Department of Planning and Infrastructure
GPO Box 39
Sydney NSW 2001

**RE: THOMAS STREET CAR PARK SITE CHATSWOOD MP09_0066 MODIFICATION 3
PROPOSED MIXED USE DEVELOPMENT**

Greg Woodhams
Environmental Services Director
Willoughby City Council

GROUND FLOOR PLAN
A-0100 C
SECTION 75 W SUBMISSION

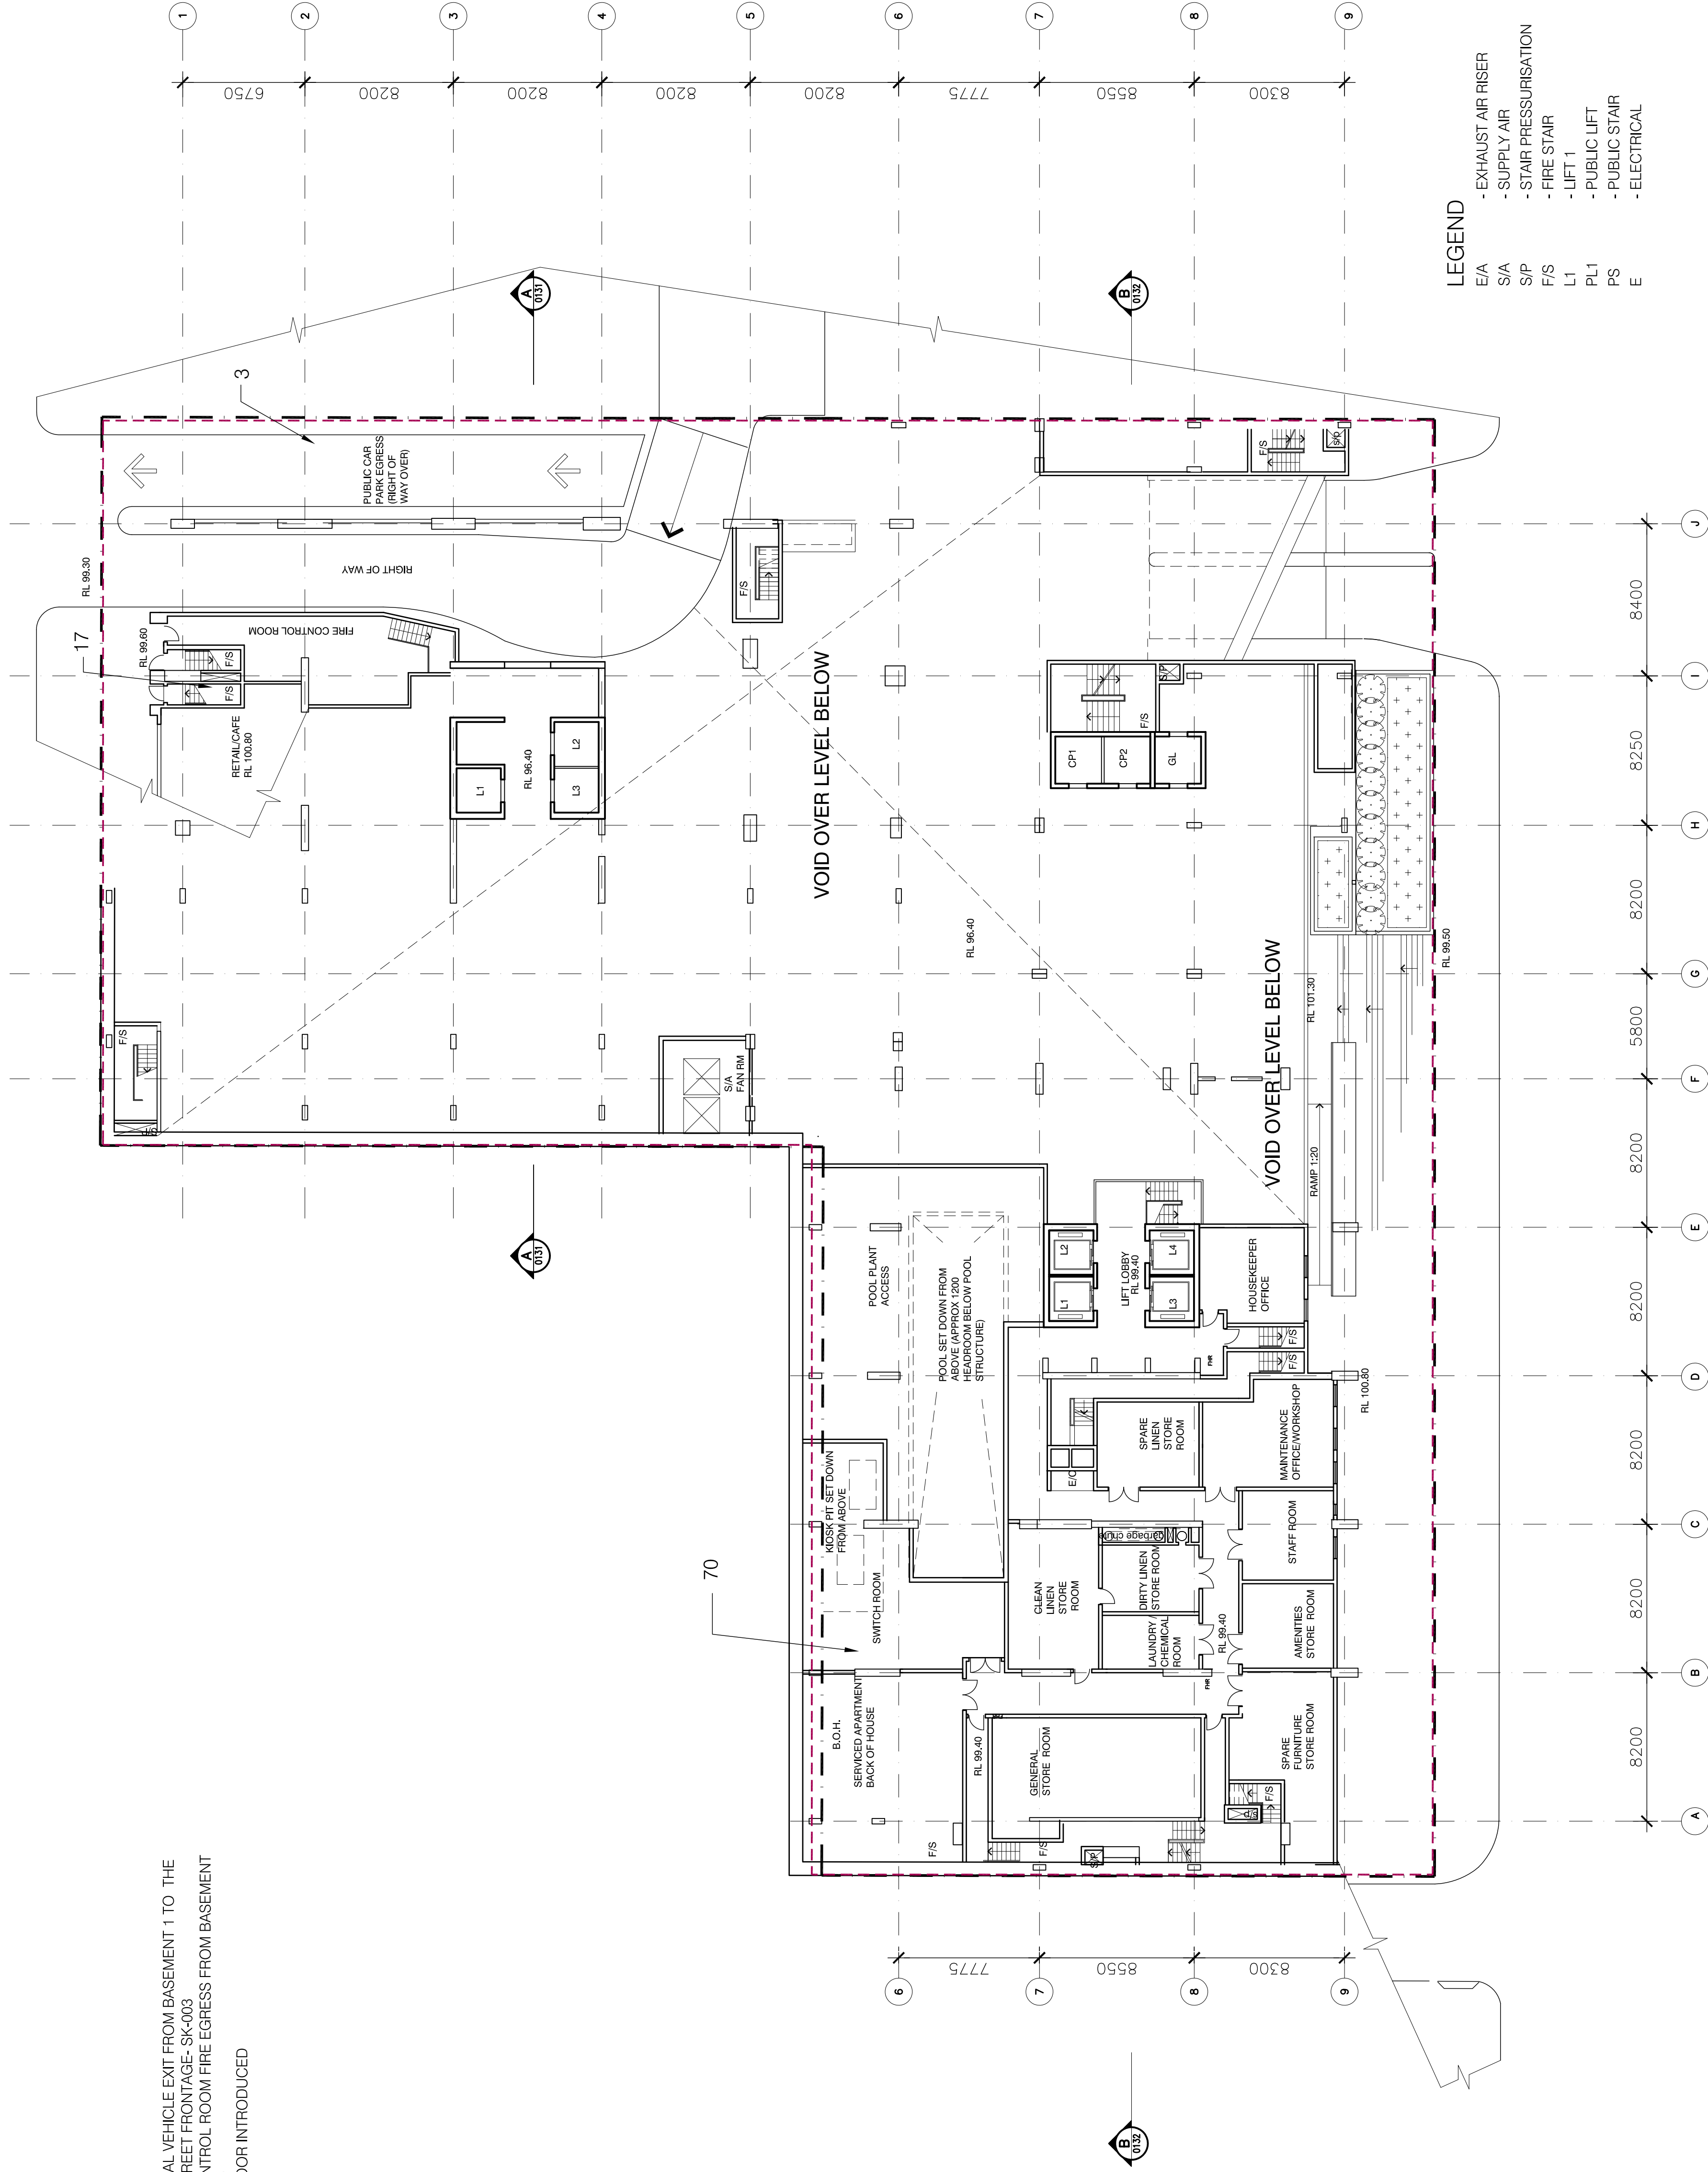
3. The treatment of the fire stair access to Thomas Street. The approved plans (Ground Floor Plan A-0100/B) presented a narrow stair wall to the street with the stair access being setback from the site boundary and screened by planting. The current plan presents a longer blank wall face to the street. The Landscape Plan submitted with the application is inconsistent with the architectural plans. The Landscape Plan shows a landscaped planter box on the street frontage screening the stair structure. This matter can be addressed by a condition requiring that the architectural plans be modified to comply with the landscape plan including provision of screen planting

SP 5

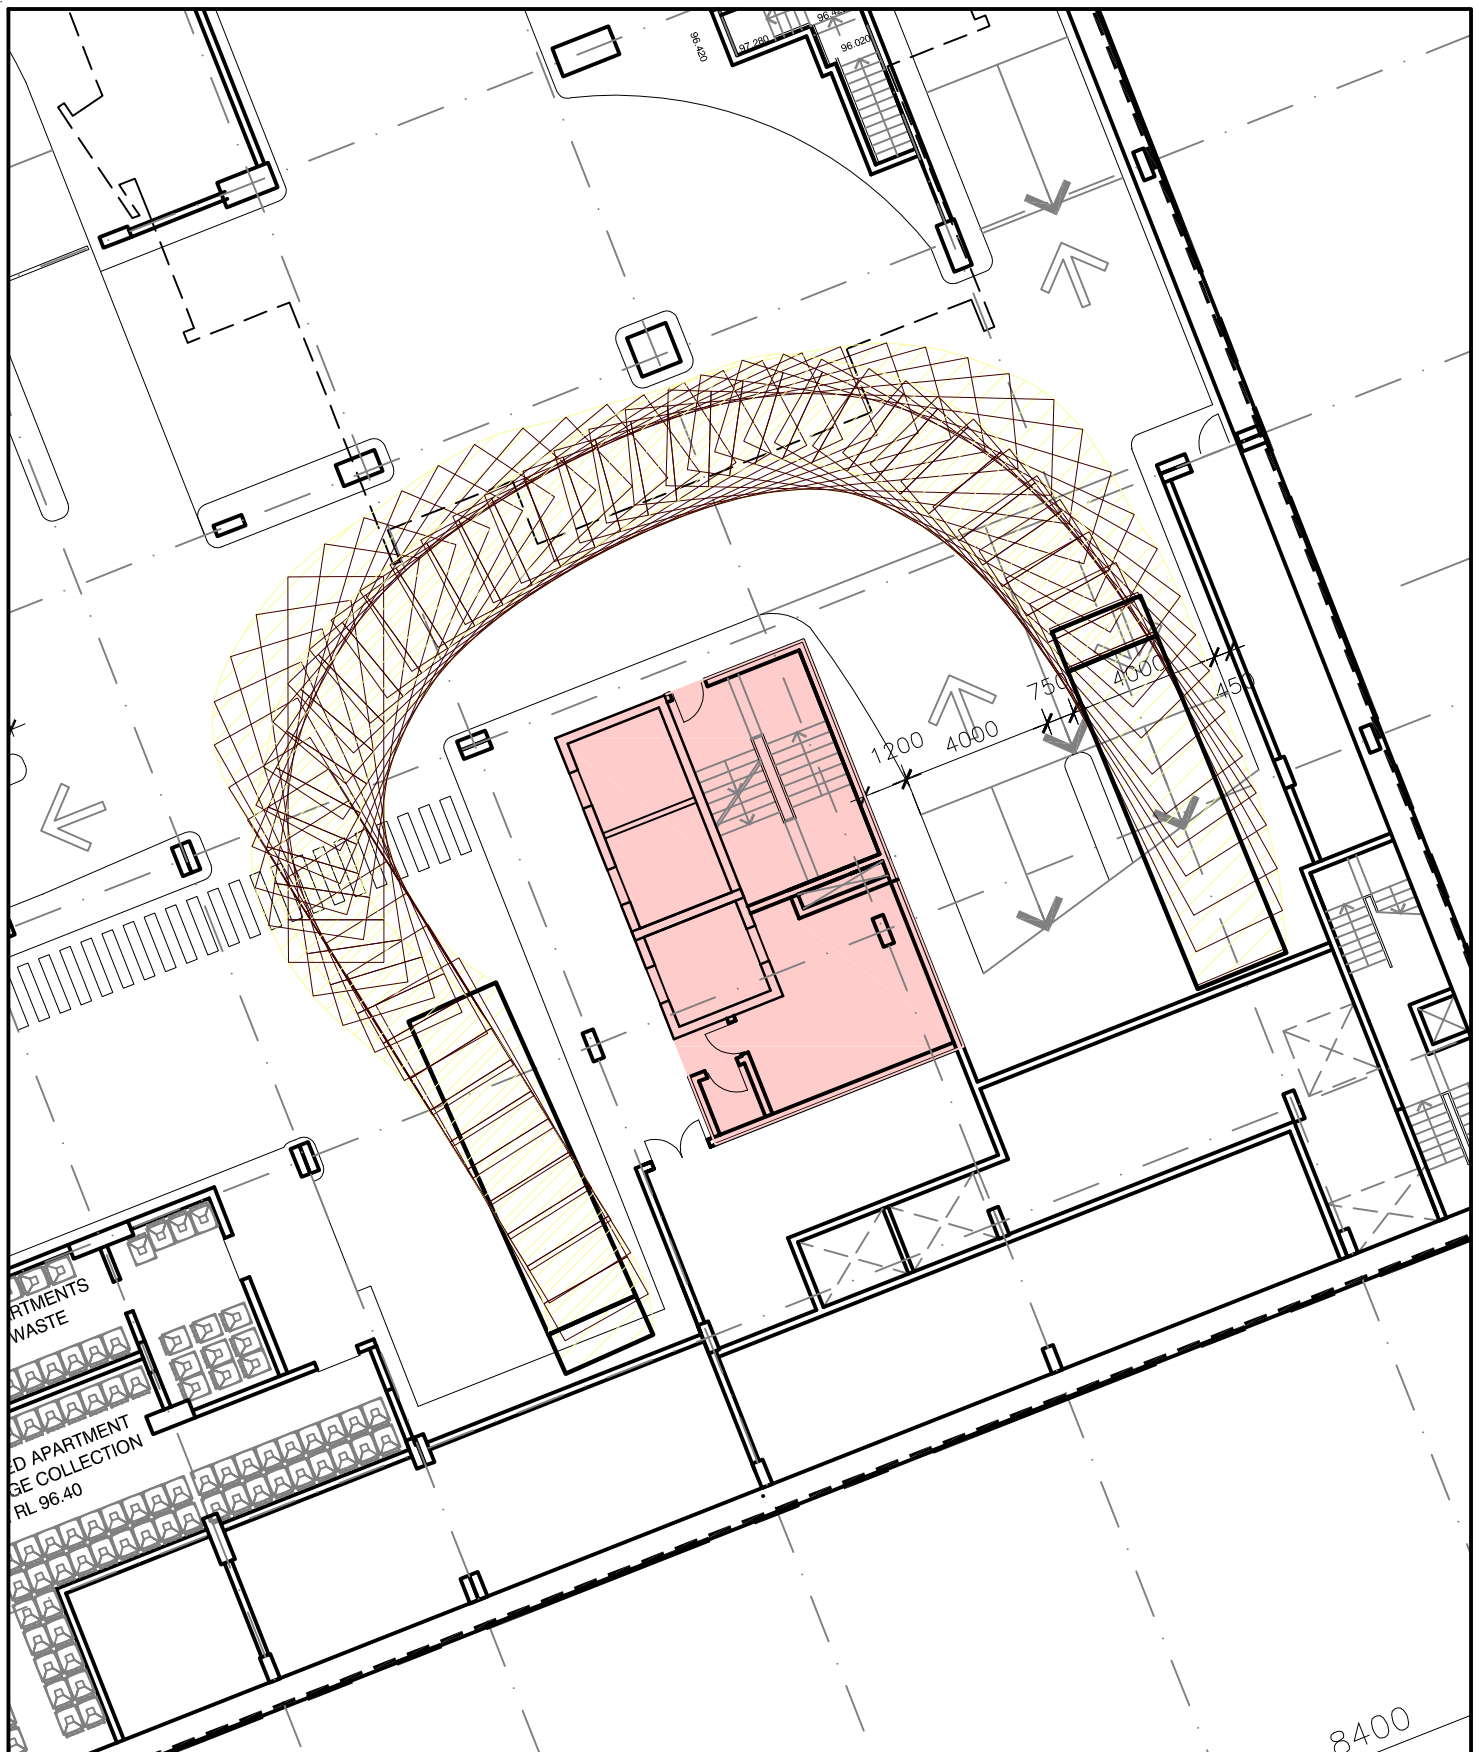
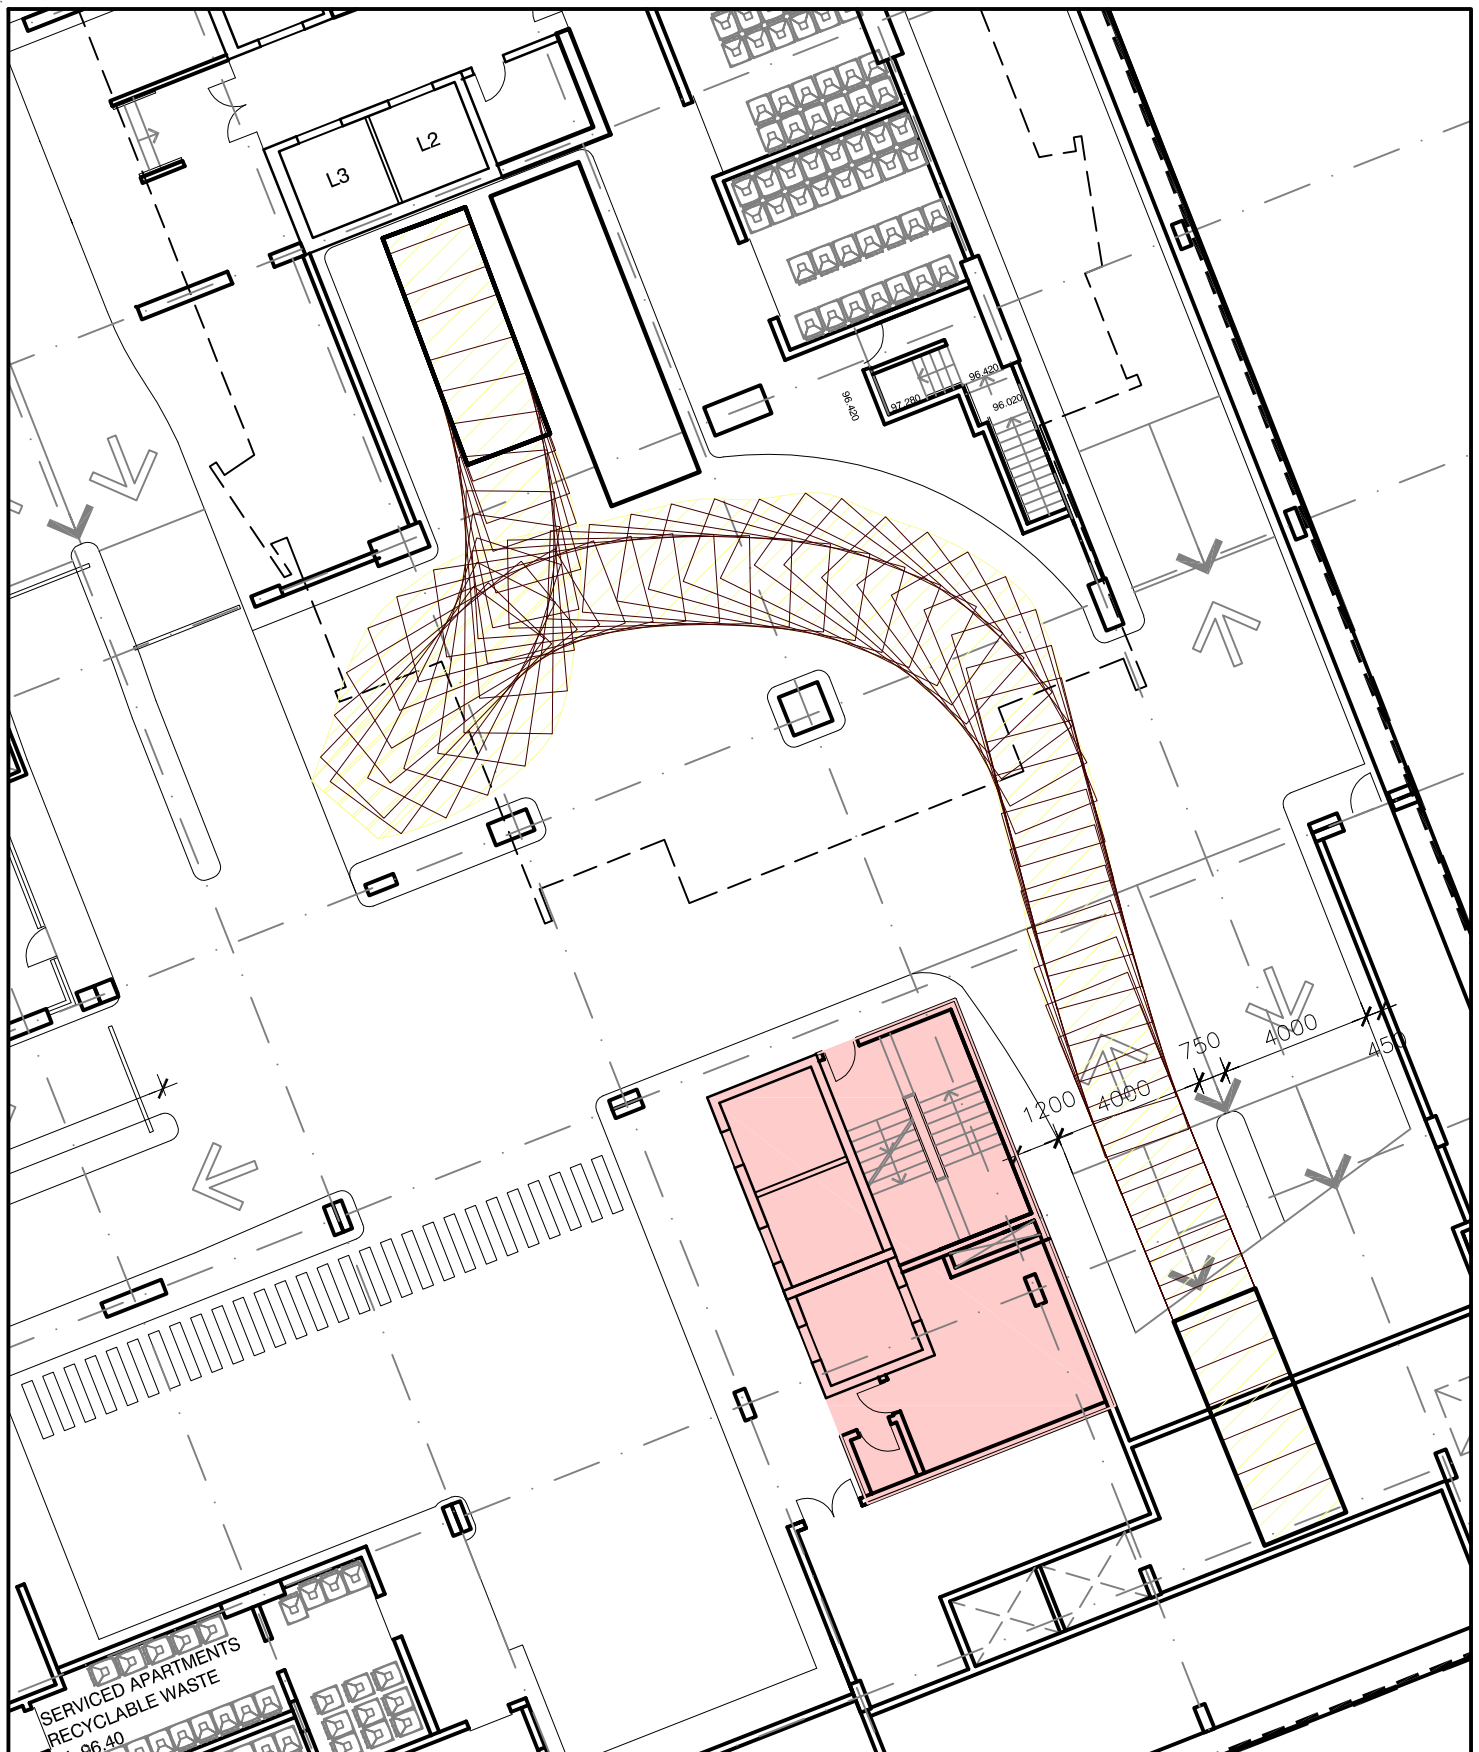
The Traffic report also confirms that the maximum size waste vehicle that can access the site and manoeuvre in the loading docks is an 8 metre rear loader and, for any delivery truck to the site, is 8.8 metres. This will increase the frequency of the waste service that is required for the site. The report notes that traffic regulations allow trucks to turn from other than the kerbside lane. This may be acceptable in the case of older existing development but a new development site must accommodate the demands for servicing the site without impact on the surrounding road network and especially on a busy arterial road such as Albert Avenue. This needs to be addressed by the Proponent by adjustment of the entry layout.
